Epping to Thornleigh Third Track Proposal. Application number SSI 5132.

☒ We object to the Epping to Thornleigh Third Track Proposal and consider that the EIS is inadequate and does not address the full impact of this proposal. It will cause untold damage to the health of residents and to the fabric of the Beecroft Cheltenham Heritage Conservation Area. Do not approve this project, reconsider the alternatives and protect the community.

Figure S.6 Cross-section and elevation - New Cheltenham Station concourse building (see also S.5 for artist's impression)

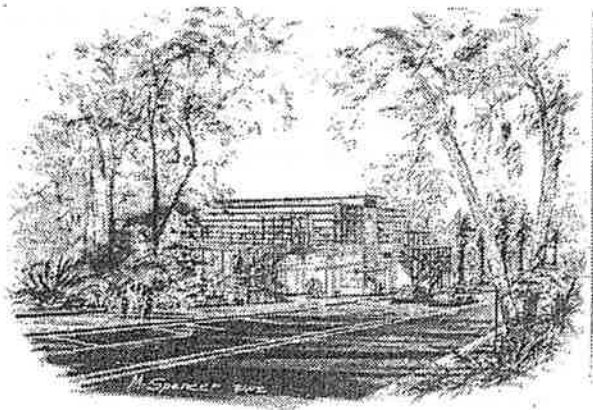
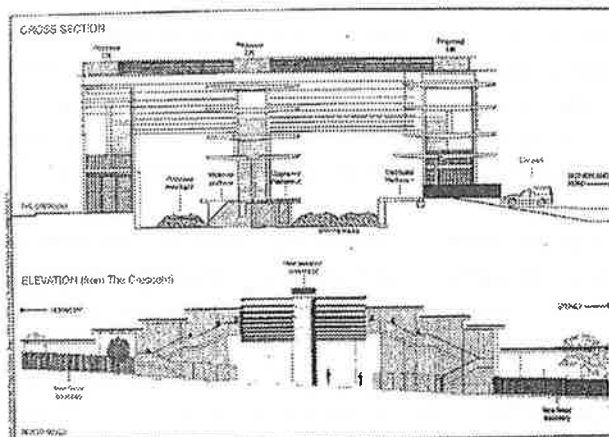
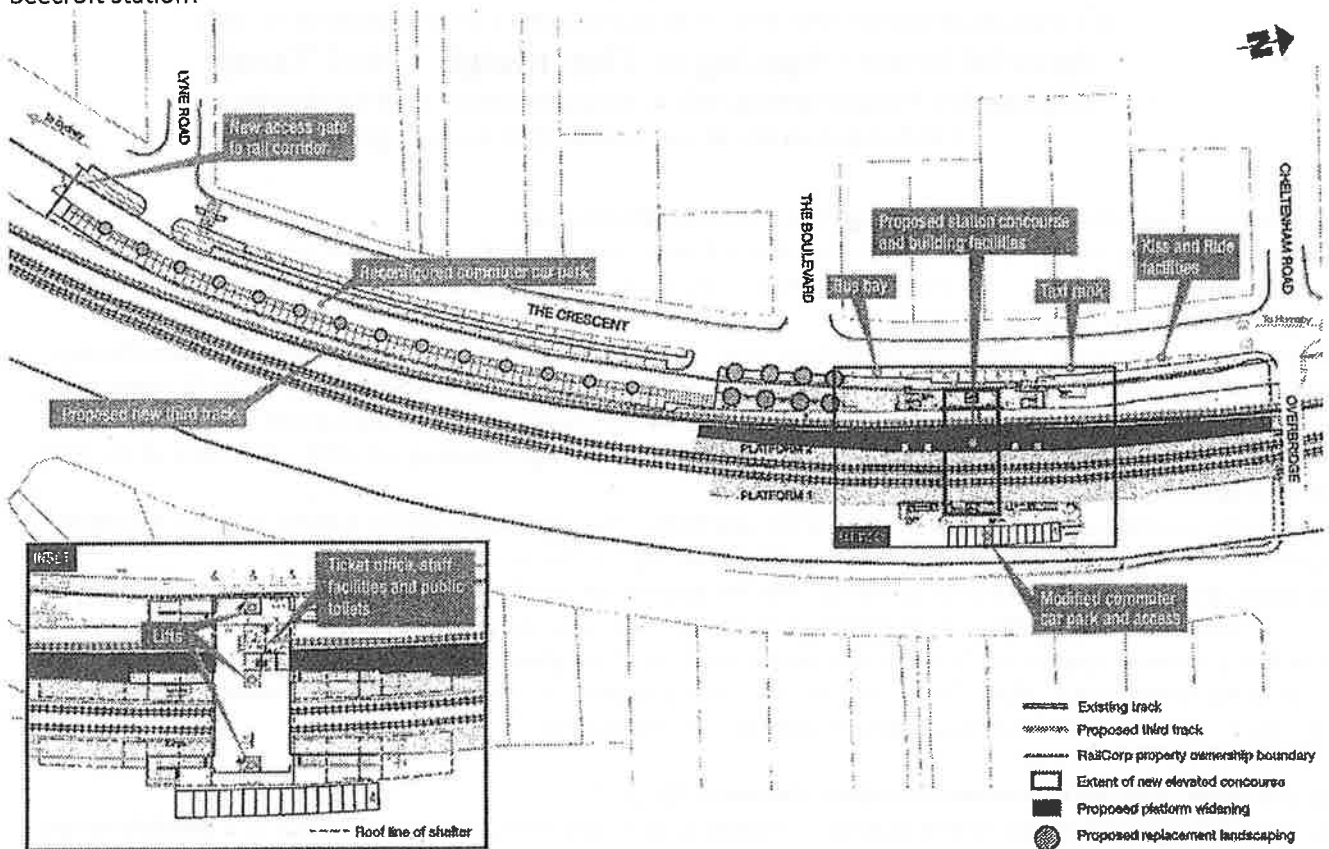
- The proposed redevelopment of Cheltenham Station shows no regard for the HCA. The visual impact of the proposed 13m high glass and steel concourse is totally unacceptable in this HCA.
